## Department of Primary Industries

### **West Culburra (SSD 3846) Supplementary Response to Submissions**

**DPI detailed comments on the supplementary response to submissions**

WEST CULBURRA MIXED USE CONCEPT PLAN

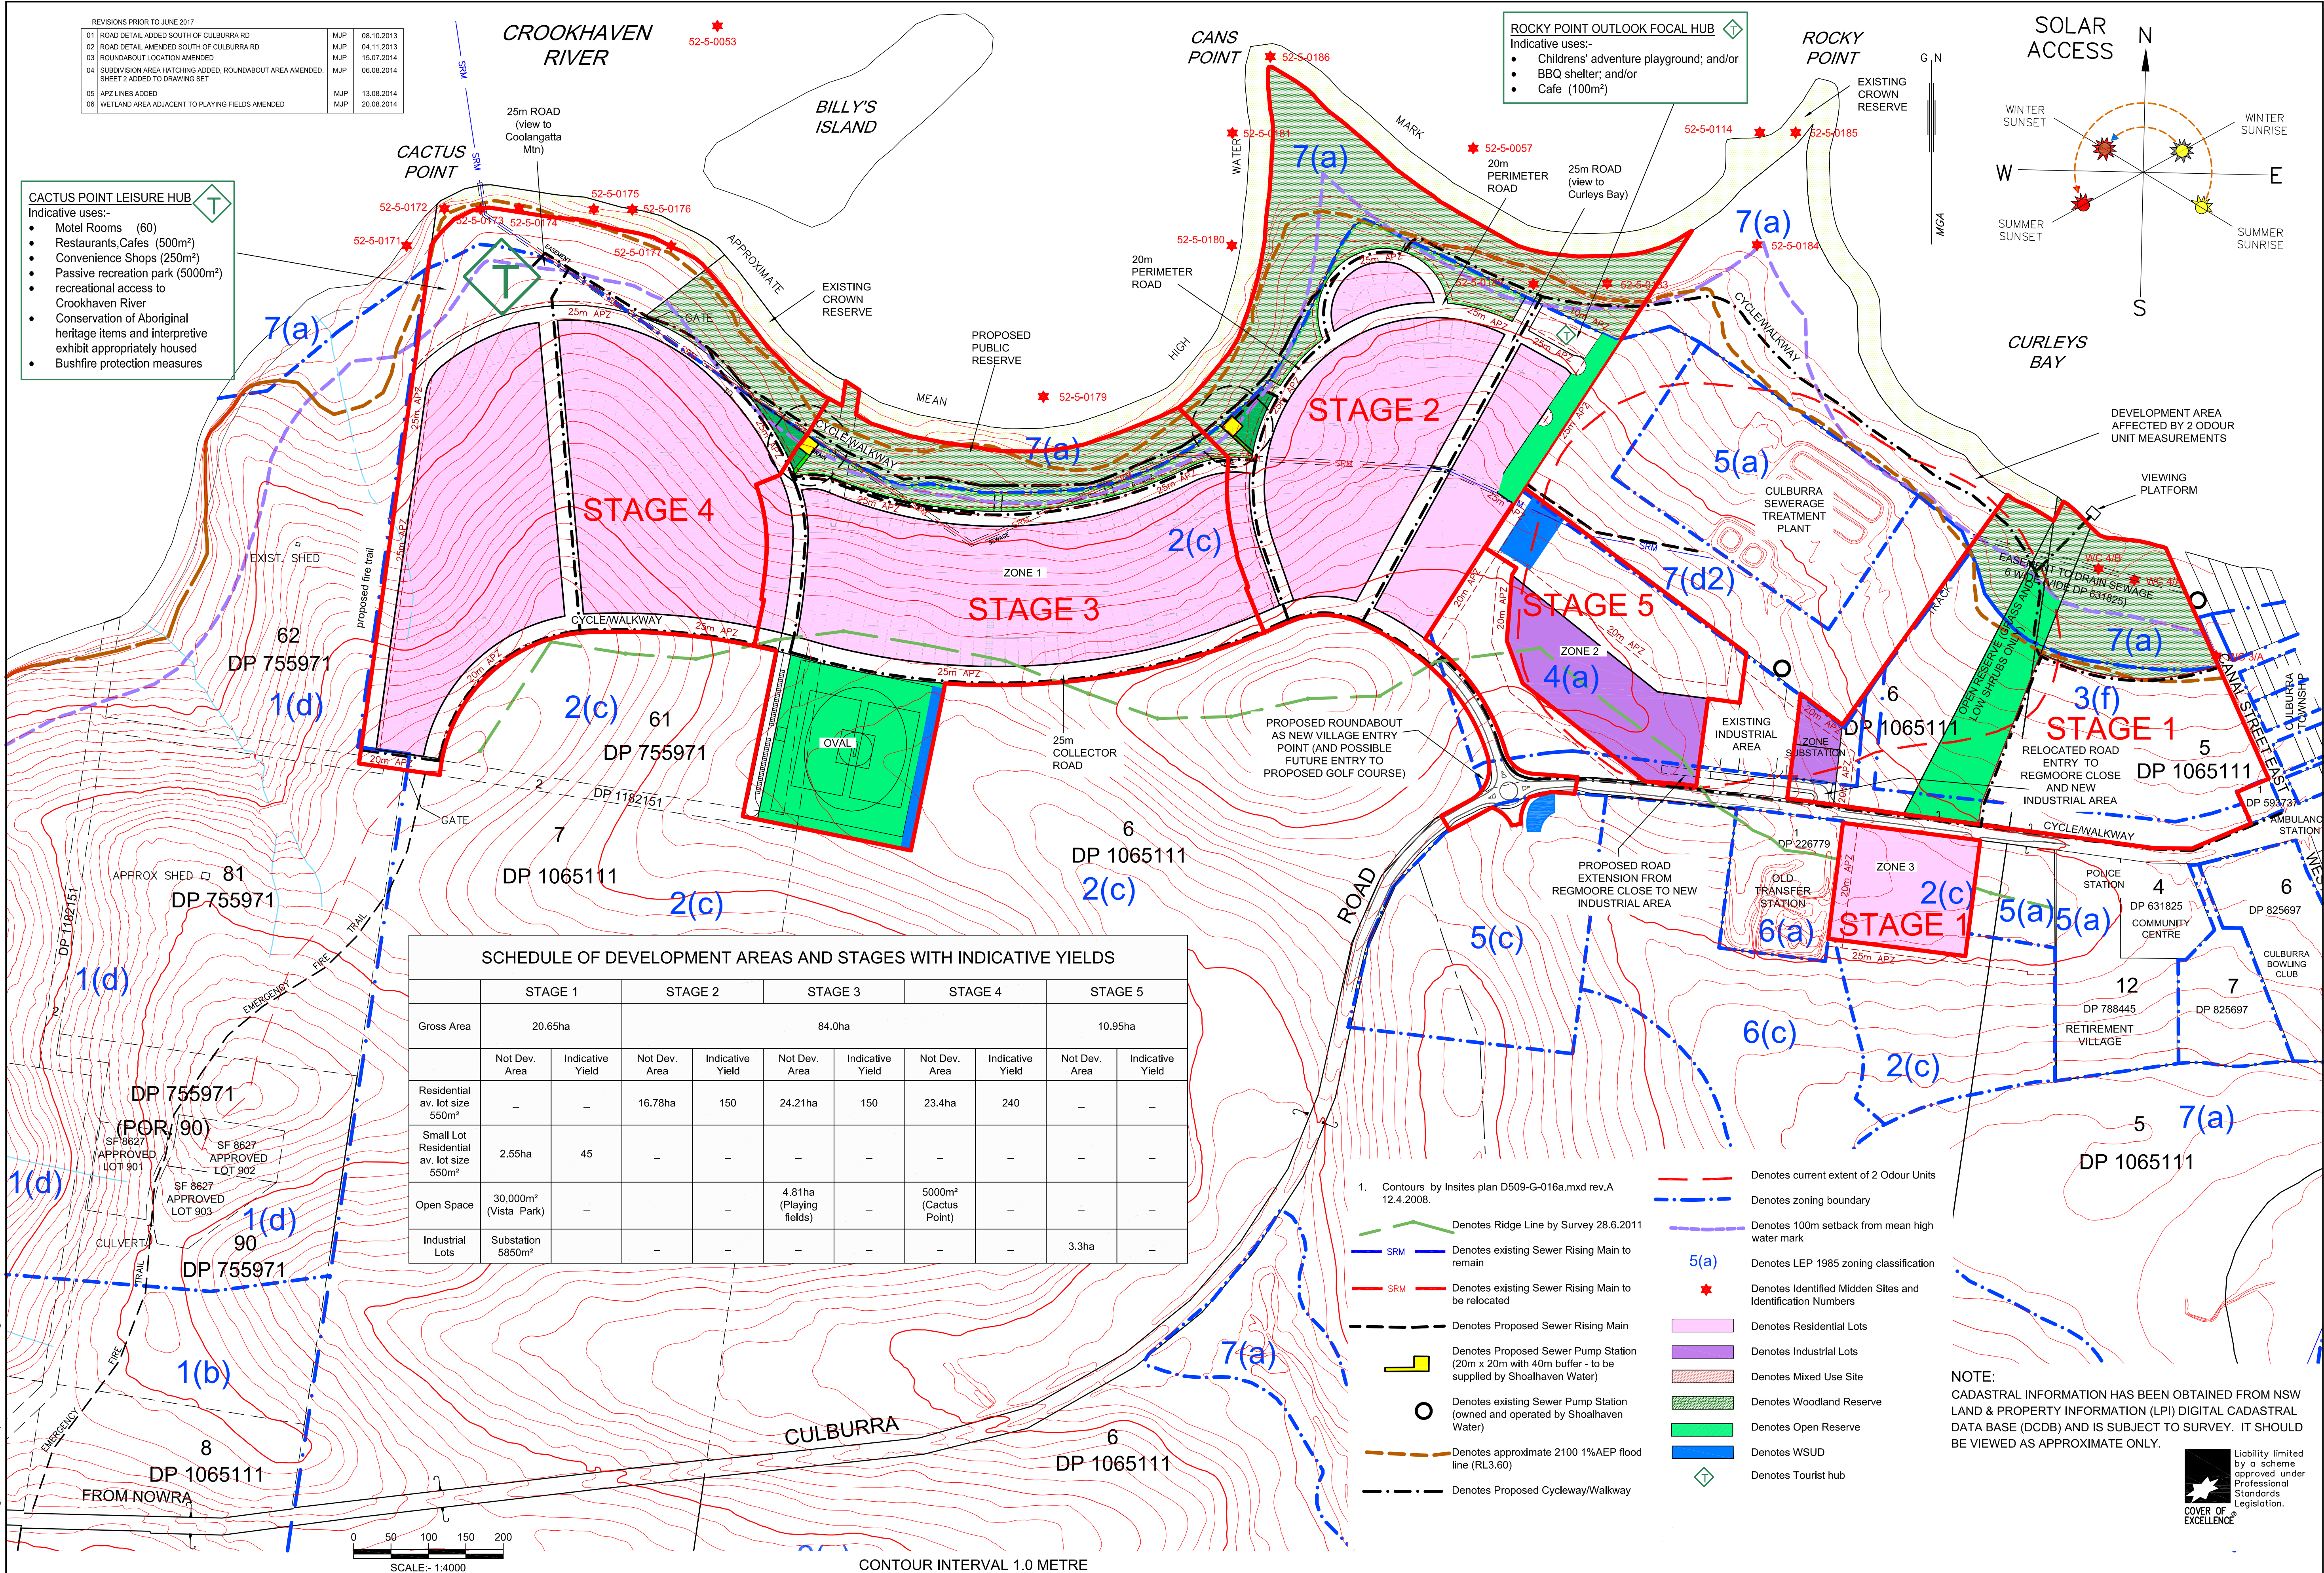
- Deletion of proposed view corridors and the leisure/tourism hub at Cactus Point (and associated clearing of vegetation).

DPI acknowledges that the proposal includes a 100m riparian buffer between the Crookhaven River and most of the residential development, and that the number and type of ancillary developments within this buffer has been scaled back such that it will now be better able to perform its intended function. However, the proponents have reconfirmed their intent to clear parts of the buffer down to the shoreline (including mangrove vegetation) to create “vistas”. These will compromise the effectiveness of the buffer.

Lands & Forestry does not support the clearing of foreshore vegetation on Crown land, above or below the mean high water mark for "vistas" as is proposed by the applicant.

The proposed foreshore tourism development ("leisure hub") at Cactus Point remains a component of the proposal. Despite concept planning for this aspect being deferred until later stages (Stage 4) in the approval process, it is clear that the proponent intends to seek some form

of waterside, tourism/recreation focussed development (motels, restaurants, cafes, tourist oriented shops) which is likely to require clearing of riparian vegetation including mangroves and armouring of the foreshore.

DPI reiterates that the waterway adjacent to Cactus Point is a shallow intertidal mud flat which is inherently unsuited to the vast majority of waterway based recreational uses. The viability of a tourism/leisure hub at this site given the existing accessibility of numerous sandy beaches in the general Culburra area is very much open to question. DPI believes that there is little justification for clearing riparian vegetation or foreshore armouring at the site as it will continue to remain an unsuitable location for water focussed leisure activities other than possibly canoeing/kayaking at high tide.
